## **DELEGATED REPORT**

<b>APPLICATION NUMBER</b>	S6/2005/0225/FP and S6/2005/0226/LB
<b>LOCATION</b>	Mymwood House, Shepherds Way, Brookmans Park, Hatfield
<b>PROPOSAL</b>	Alterations and Extensions to Care Home

Drawing No JDA/03/940/P.APP/ELEVS.001

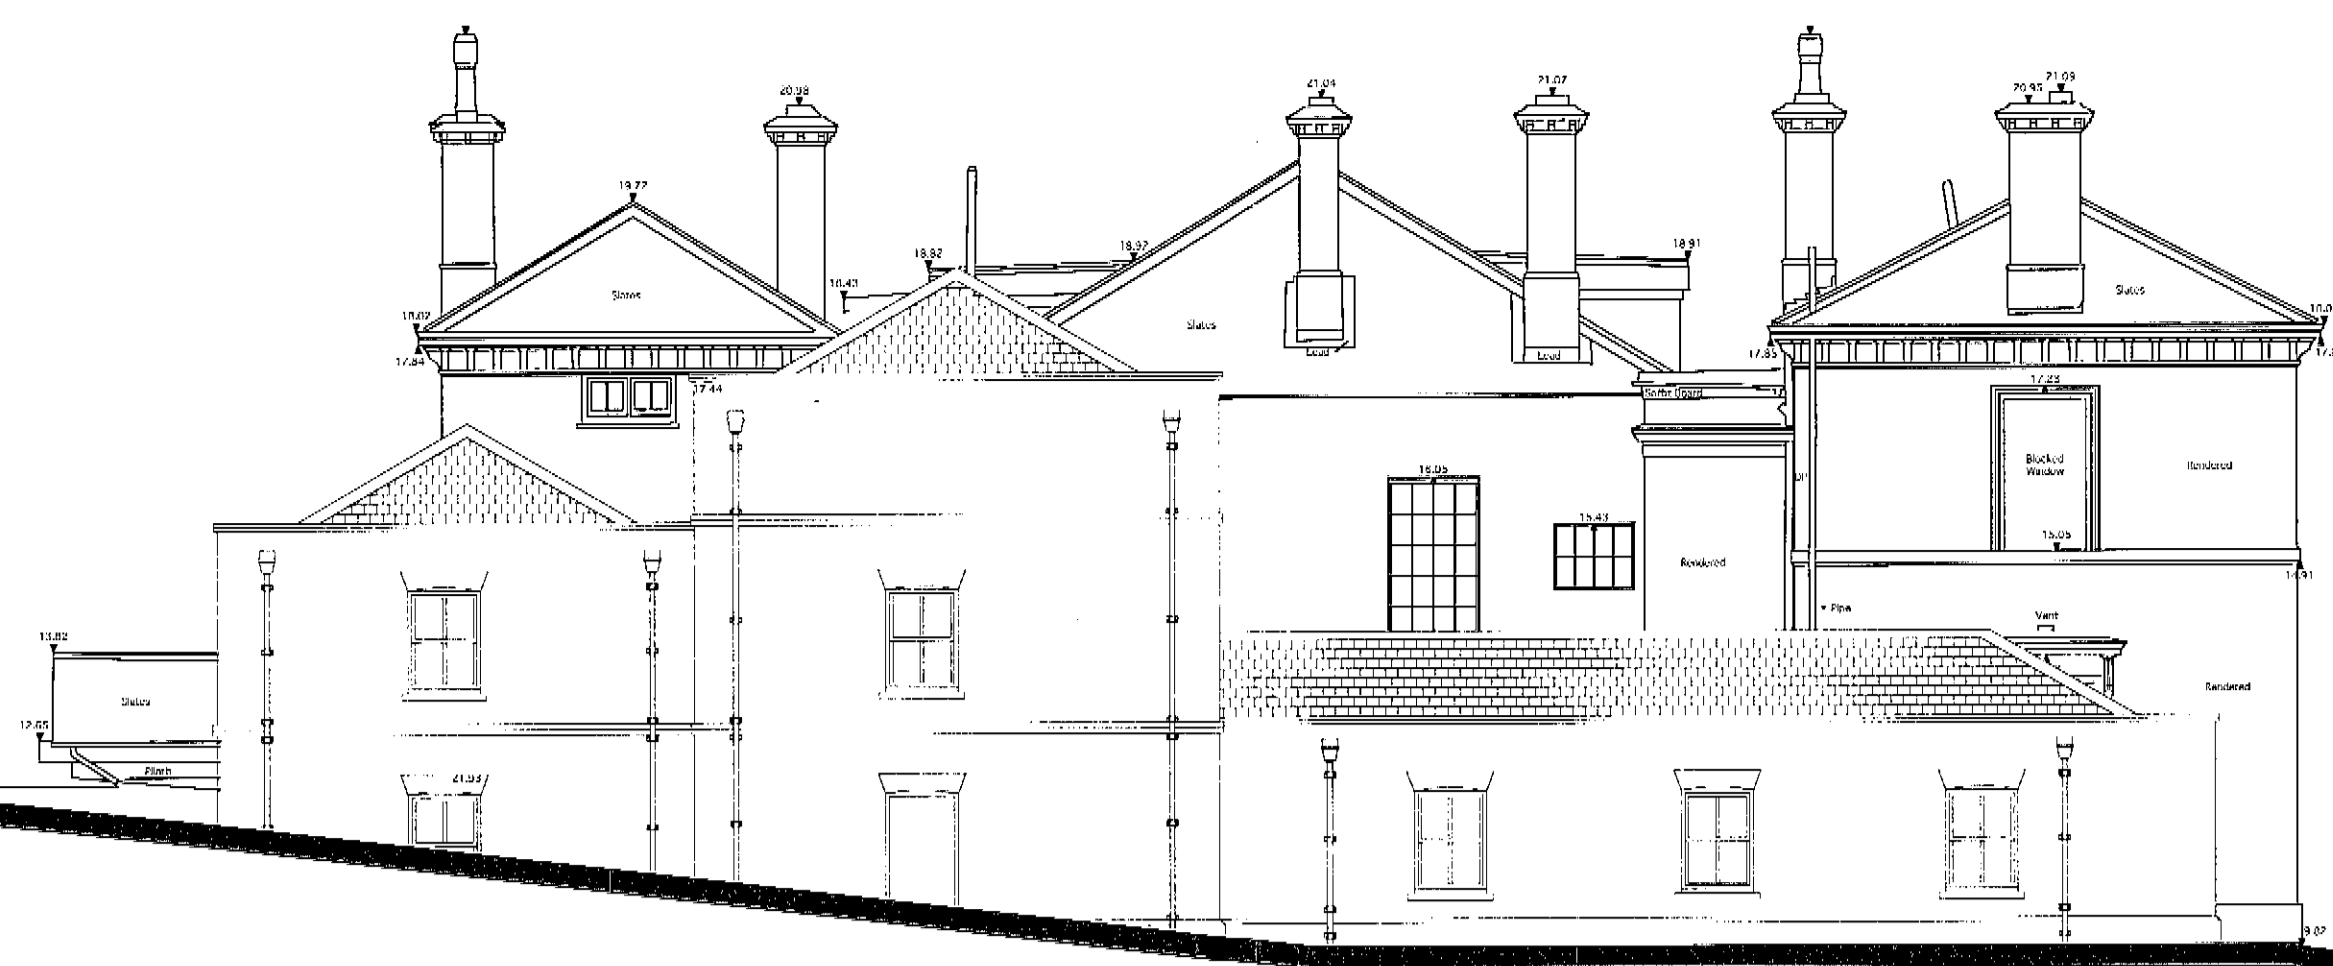
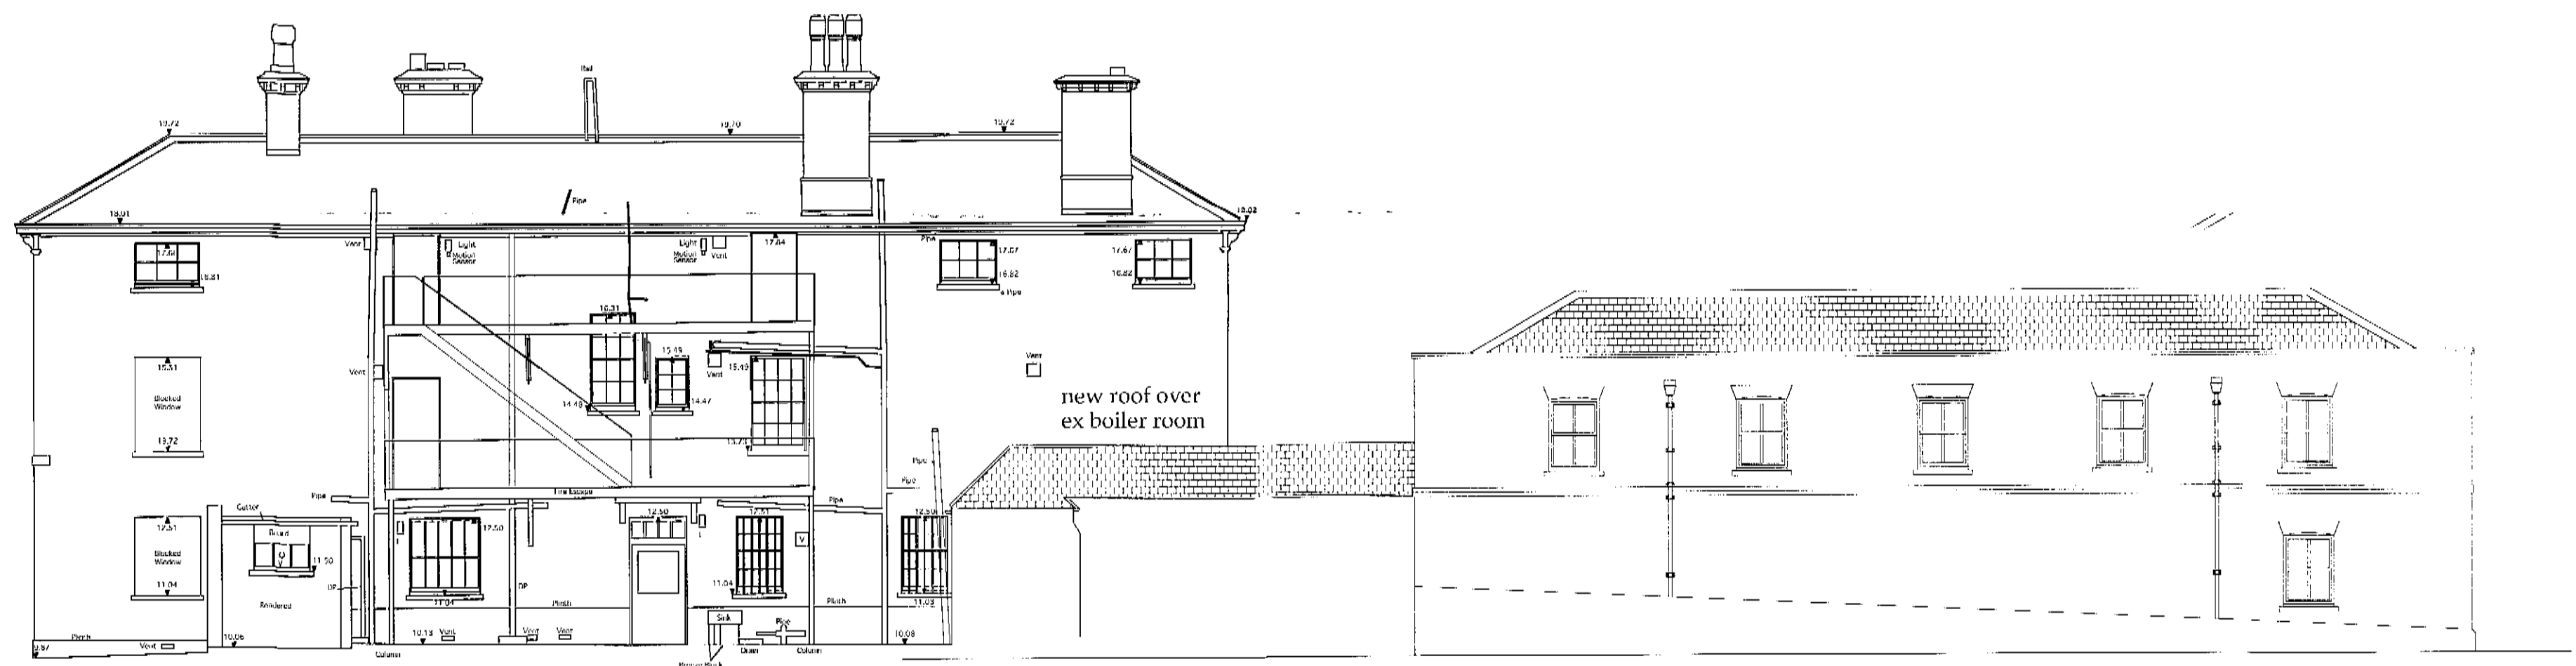
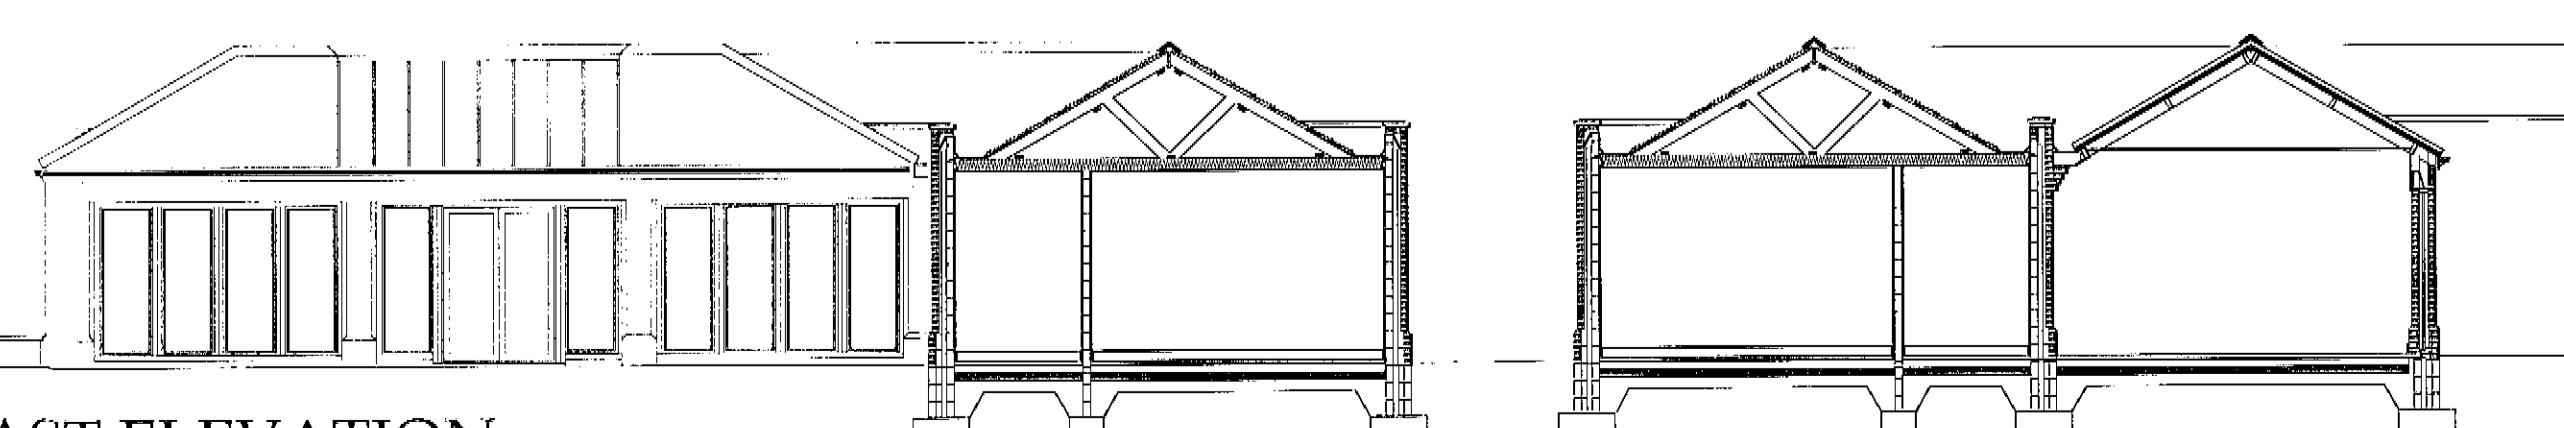
It is considered that the form and location of the extension proposed represents an unacceptable increase in the overall bulk and size of this building within the Green Belt. An extension of this size and design would make the building significantly more prominent visually, and this is particularly unacceptable in terms of its impact on open Green Belt land to the west.

Mr Craig considers that the applicant has responded partly to the suggestions made at the meeting in December 2004, but he is not satisfied with the combination, in the location and form proposed, of one and two storey accommodation. Mr Craig considers that the large tall block on the north elevation is particularly bulky and unattractive. It seems be wasteful of space on the upper level which is occupied by a lift, plant room, staircase and questionable circulation space. This block protrudes awkwardly into the proposed courtyard, as does the proposed conservatory. Perhaps with appropriate hard and soft landscaping the courtyard space can be treated in a manner that will render it more practical and visually acceptable.

The proposals do not respect the character, appearance and setting of the building

in terms of design and scale and will detract from the appearance of the existing building to the detriment of the character and appearance of the Listed Building as a whole.

When Mr Craig and I visited the site on 23 March 2005, we discussed the possibility of locating the two storey block, if one is required, at the rear of the site i.e. on the eastern side of the courtyard, although a simple extension incorporating a single storey block ranged around an attractive courtyard would be preferred. However, Mr Craig considers that, although the design of the proposals represents an improvement on the original scheme submitted at pre-application stage, in their present form he could not recommend approval.

Drawing No JDA/03/940/P.APP/LAYS.001

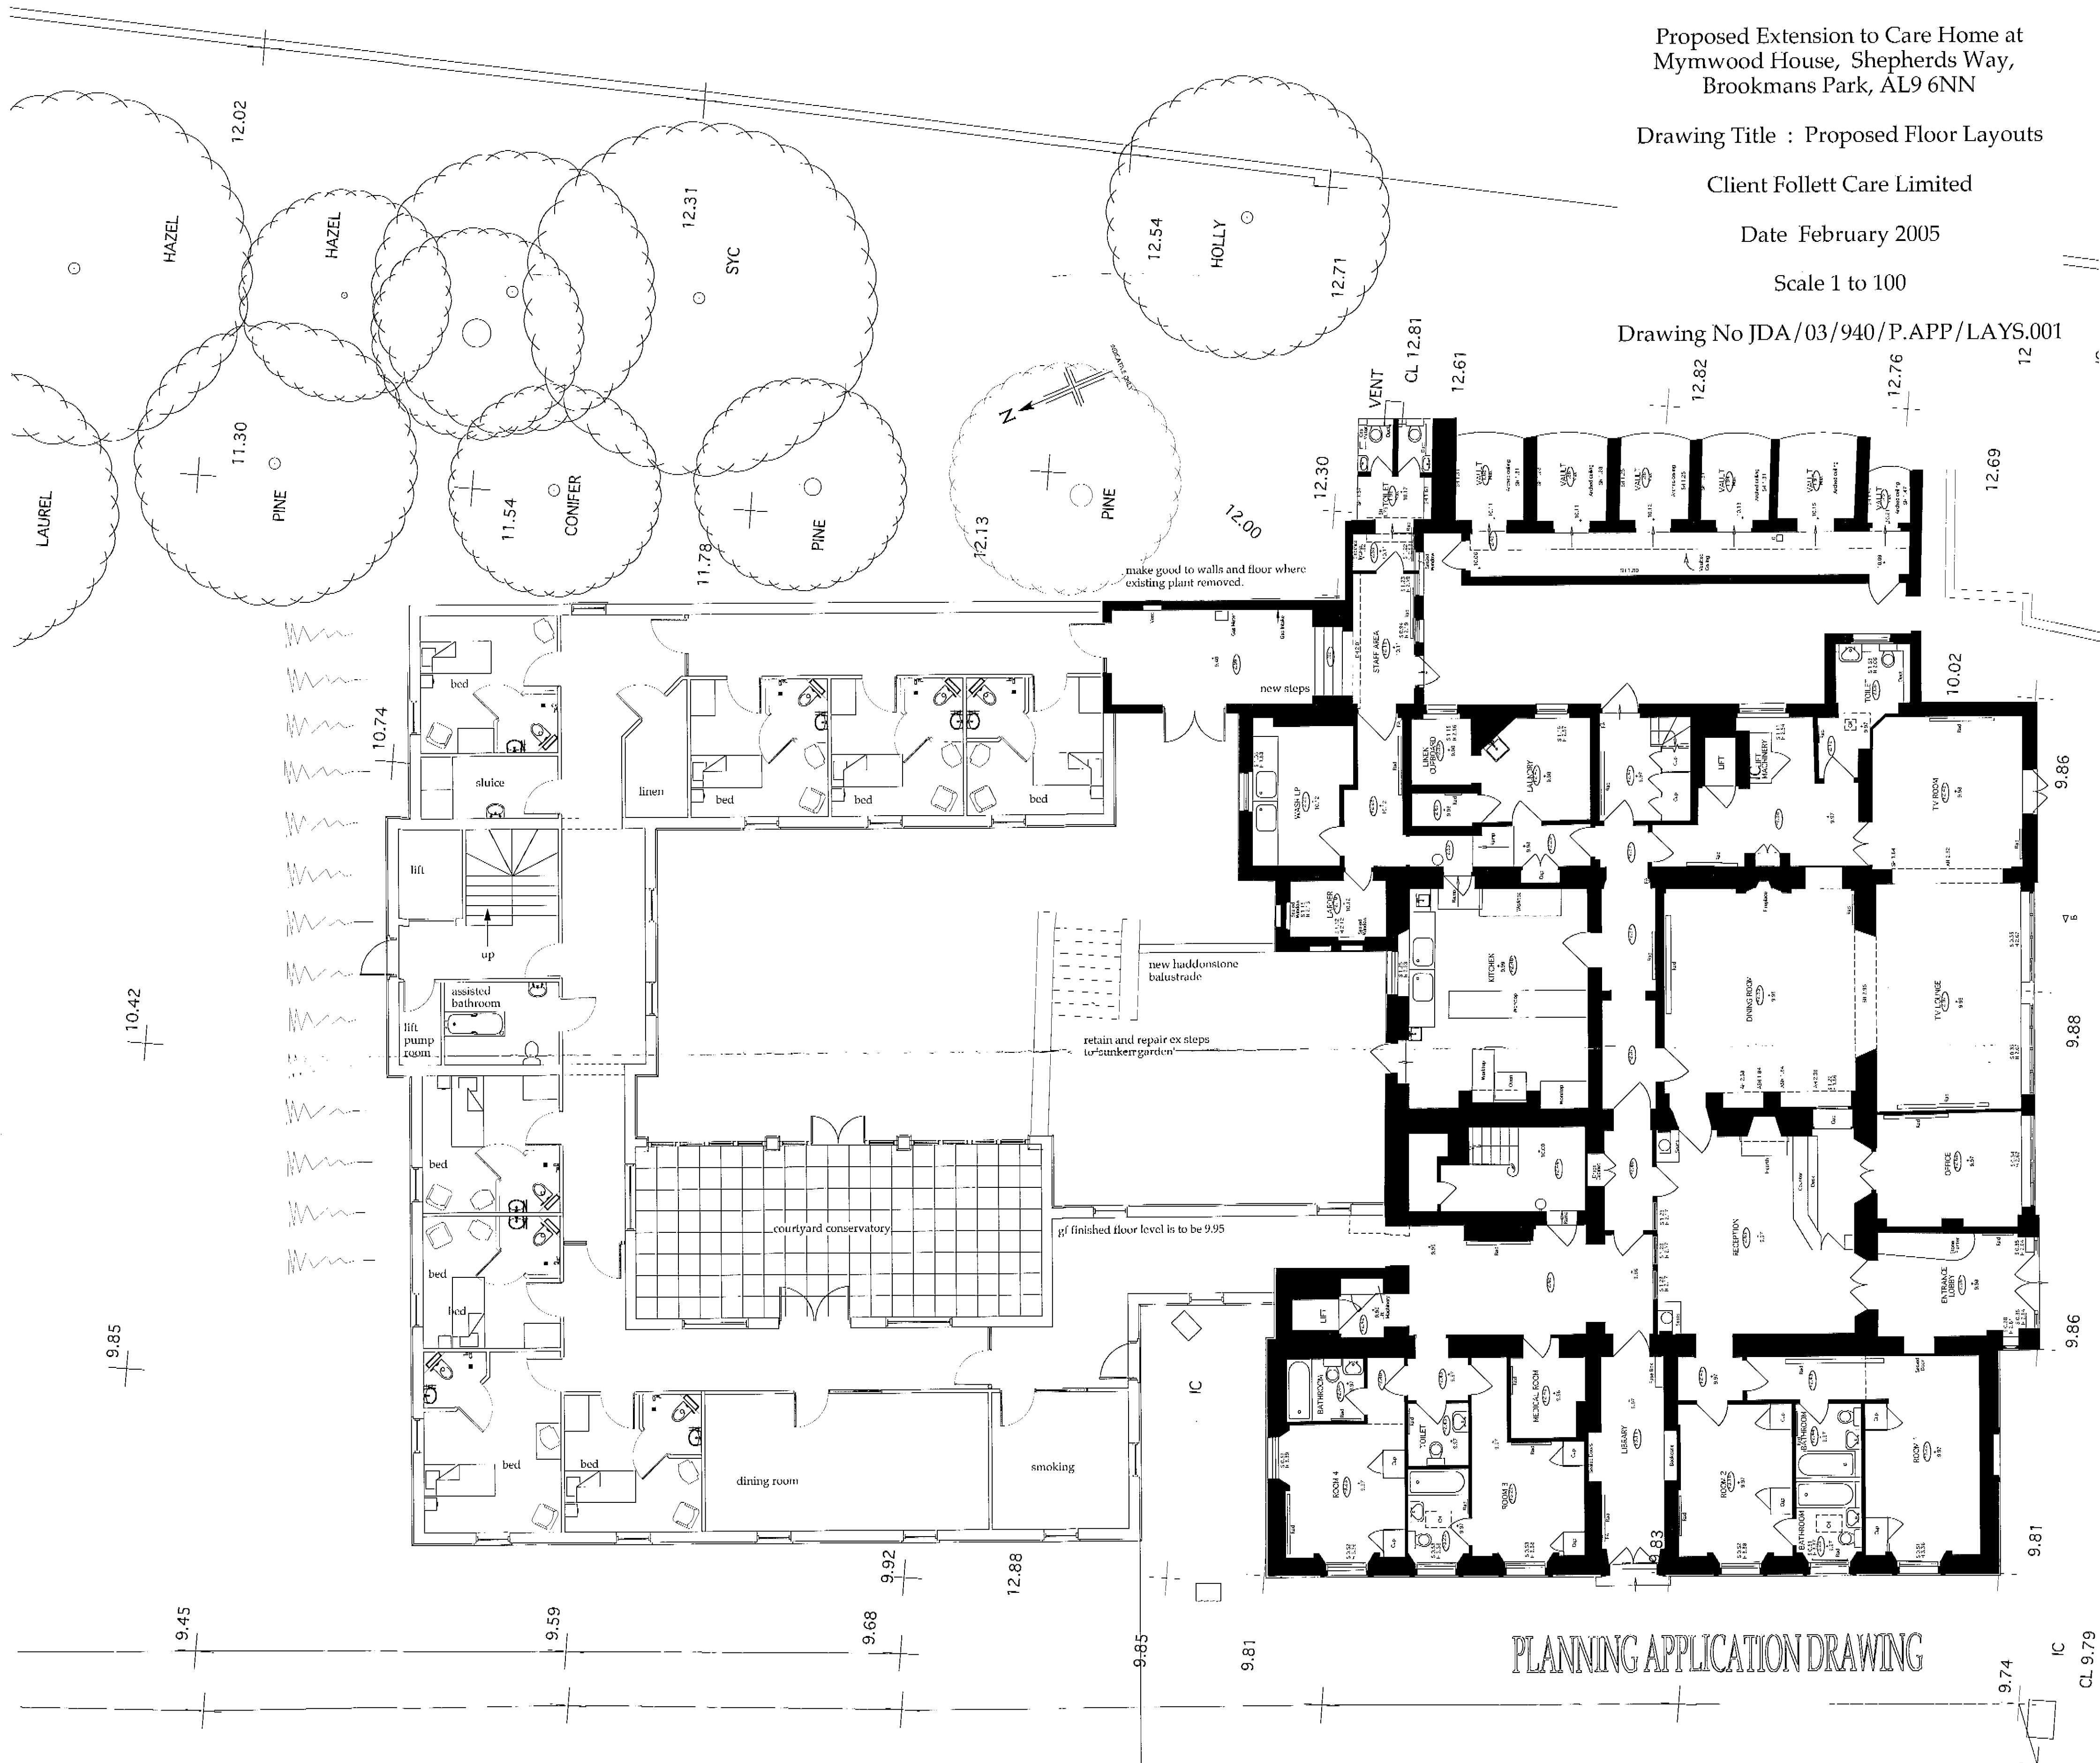
It has been Mr Craig's view in the course of pre-application discussions that any extensions to this listed building would require very careful handling. The building sits on an elevated site, which is prominent from lower ground in the vicinity and from high ground across the valley to the north. Alternative forms of development were explored at a meeting with the architect and agent in December 2004. Rather than a two storey replica of the existing building sited nearby and connected to it by a link, it was suggested that a smaller complex perhaps in the form of a single storey wing or U shaped block ranged around an internal courtyard would be more appropriate.
